WEST SUSSEX COUNTY COUNCIL CONSULTATION

TO:	Arun District Council FAO: Miss K Welch
FROM:	WSCC - Highways Authority
DATE:	6 April 2022
LOCATION:	166 Littlehampton Road, Ferring, BN12 6PH
SUBJECT:	FG/36/22/HH Two storey side extension, single storey front extension and new entrance and new vehicular access.
DATE OF SITE VISIT:	n/a
RECOMMENDATION:	More Information
S106 CONTRIBUTION TOTAL:	n/a

Drawing Title:
Site Plan and Location Plan

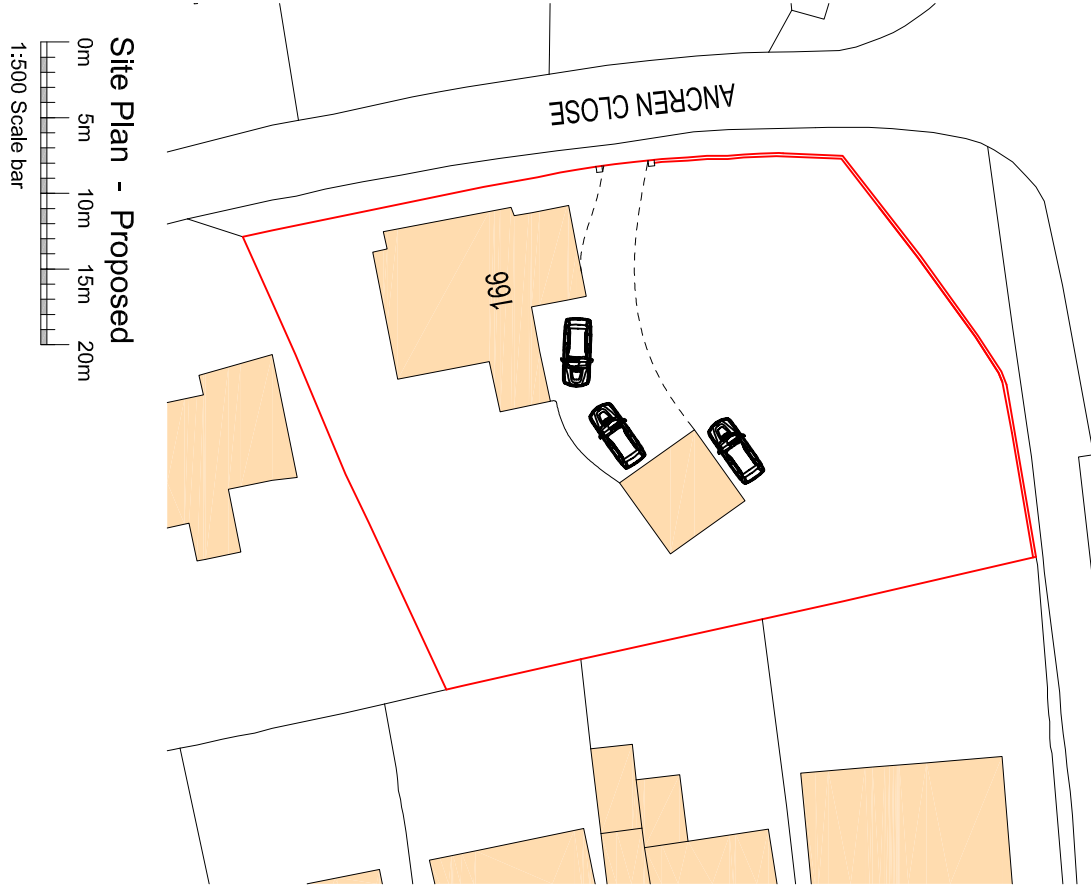
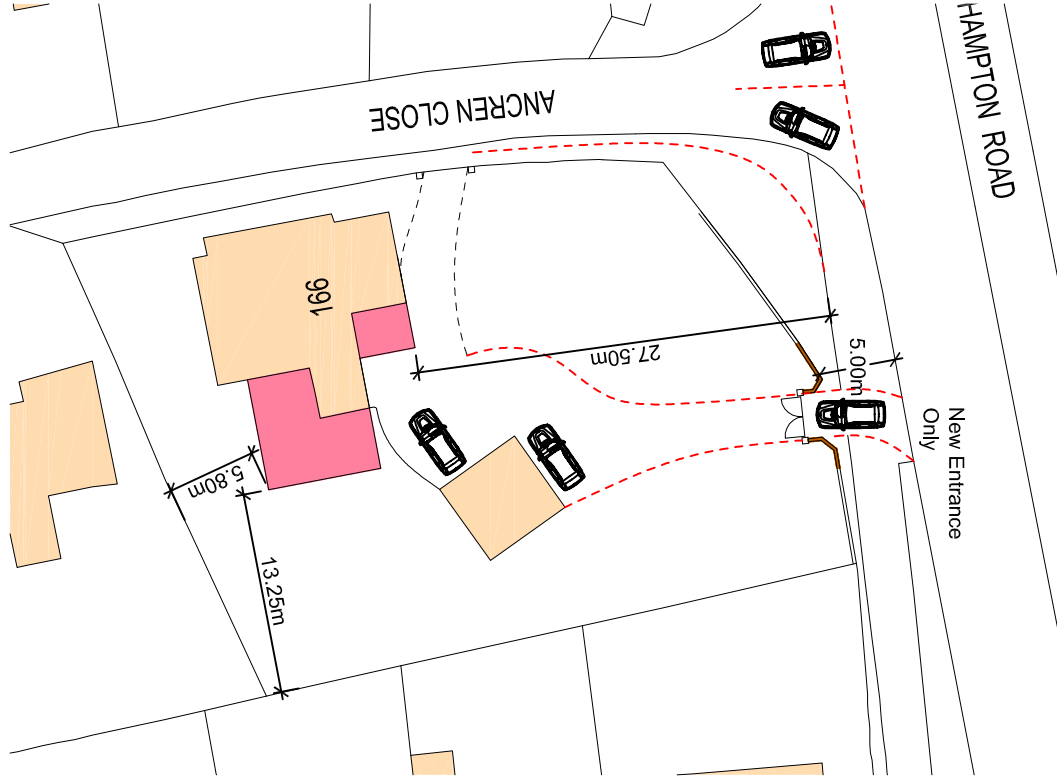
In order to implement the proposed vehicle crossover, The Local Highways Authority would require the existing bus stopping point to be relocated. This will include physically moving the stopping point, repainting the bus cage markings, constructing / reconstructing any hardstanding as required.

These works would be subject to a bus stop relocation assessment, consultation with the bus operator and a Stage 1 Road Safety Audit. The applicant will need to meet all associated costs for the work, it will not be funded by the Local Highways Authority. Given the scale of the works it is likely that the implementation will need to be handled via a Section 278 Highways Agreement.

Given the site already benefits from adequate vehicle access via Ancren Close the applicant may wish to consider removing the vehicle crossover works from the application and seek only the domestic extension works.
